**Town and Country Planning Act 1990
Appeal by Paddy Power Plc
Site at 10 Market Place, Clitheroe, BB7 2DA**

Appeal Decision

Appeal Ref: APP/T2350/A/12/2189415

10 Market Place, Clitheroe, Lancashire BB7 2DA

Front elevation - scale 1:50 @ A0

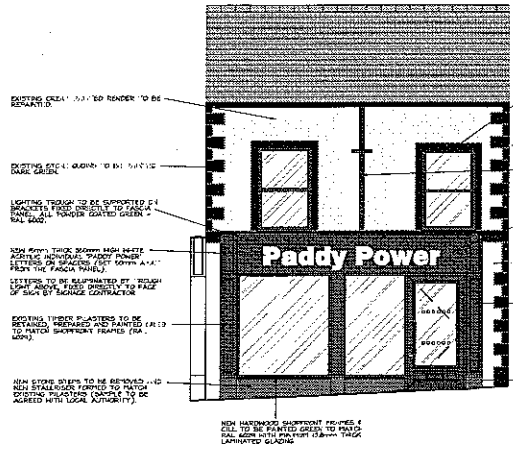
17. The Council does not take issue with all of the overall proposals for external alterations to the property, including installation of satellite dishes at the rear, and I see no reason to disagree. However, it objects to the proposed shop front and, in particular, the recessed entrance. The revised plans indicate a proposed shop front of similar overall dimensions to the existing, retaining the existing pilasters. The total area of shop window would exceed 50% of the width, albeit divided into two separate elements, and would retain an appropriate stall-riser. Hardly more than the width of the door itself would be recessed.

18. There are numerous examples, throughout the conservation area, including Market Place itself, of shopfronts, both modern and traditional, incorporating recessed elements. Although the *Clitheroe Conservation Area Appraisal* expresses concern regarding inappropriate modern materials or details on shopfronts, within the overall context, the scheme would represent an acceptable modern interpretation of traditional themes and would preserve the character and appearance of the conservation area. In addition, I am satisfied that the setting of the various listed buildings in Market place would also be preserved. It follows that there would be no conflict, in that respect, with LP Policies ENV16 or G1 or with the various paragraphs of the Framework and supporting guidance, relating to design and heritage, referred to by the Council, including paragraph 132, which requires great weight to be given to the conservation of designated heritage assets.
